Our Ref: 24/00686/HFUL
Your Ref: heat pump 19 foxes way

**South Cambridgeshire District Council
Application for Planning Permission**

Proposal: installation of heat pump

Site address: 19 Foxs Way Comberton Cambridgeshire CB23 7DL

Plan Reference Number: TQRQM24056125837423

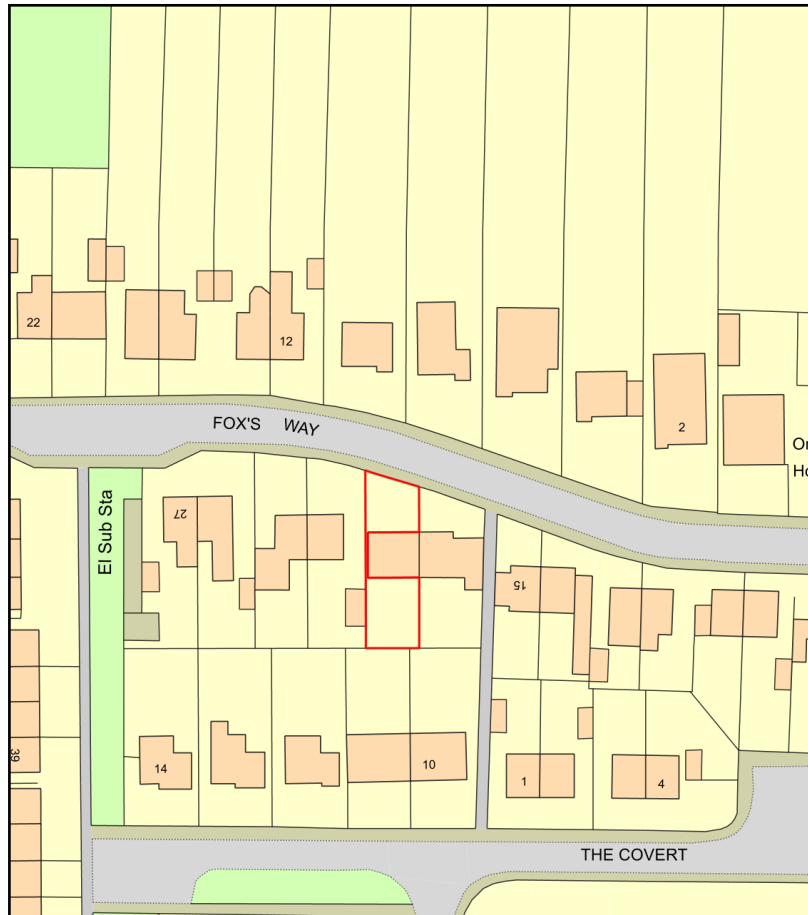
1. Please provide a location plan. Please ensure this is at a scale of 1:1250/1:2500 with 2 named roads, the site outlined in red and any adjoining land owned by the applicant outlined in blue, access to site, visibility splays, landscaping and car parking & open areas around buildings.

Please ensure the whole site is outlined in red.
